**RE: Winrock Town Center Park  
2100 Louisiana Blvd.  
Drainage Report Stamp Date: 1/17/2022  
Hydrology File: J19D058G**

**RE: Winrock Submittal Review**

In response to your review comments dated, January 13, 2022 we are replying with the following:

EXHIBIT 4

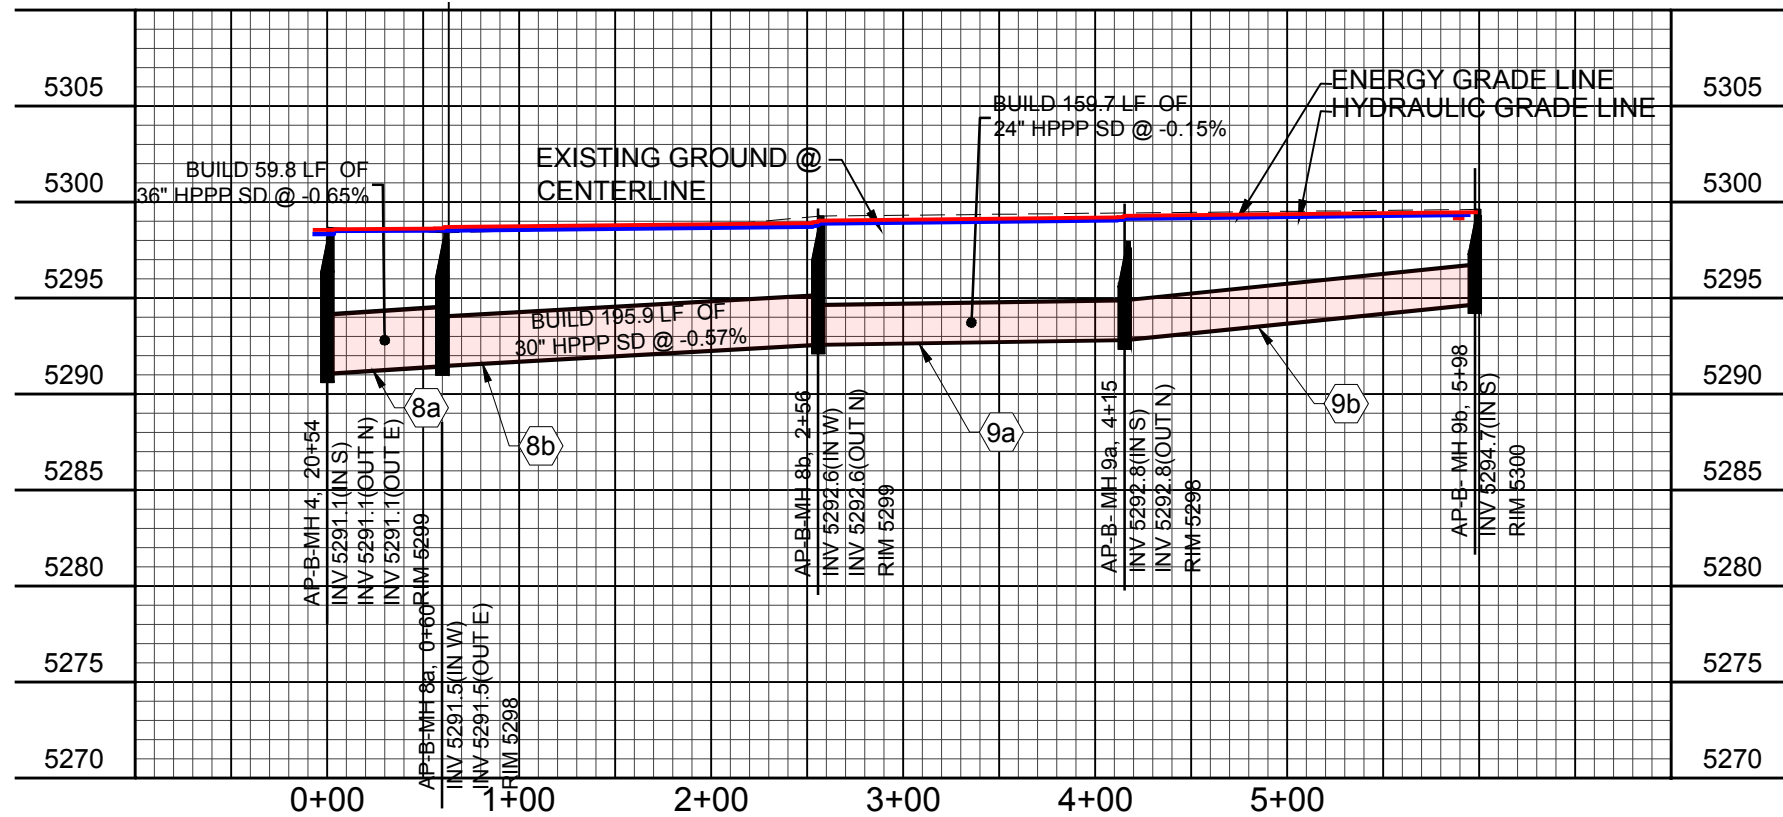
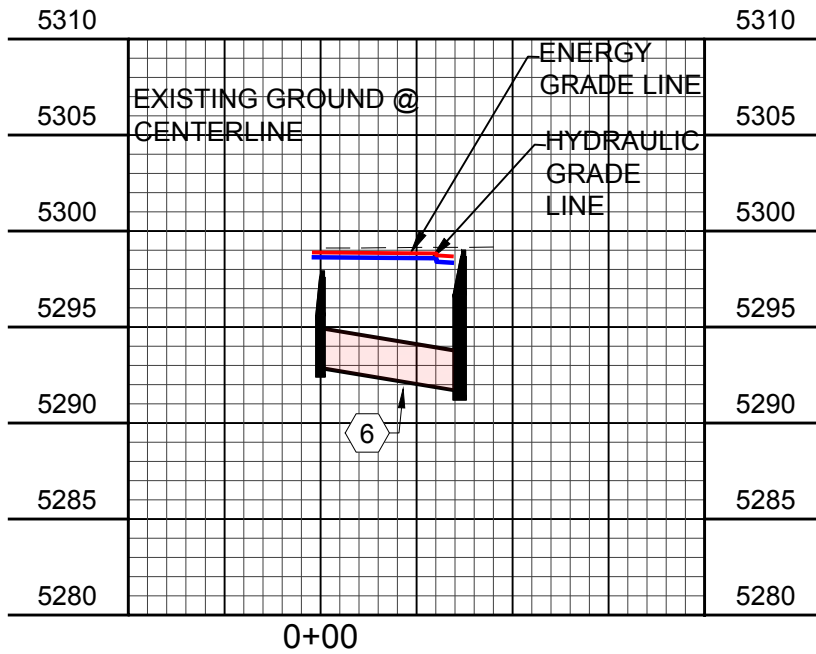
Comment # 3: On Exhibit 4 the profile of Storm Drain AP-B 500 only the surface, EGL and HGL are shown, there is no storm drain line shown.

- The storm drain is now visible.
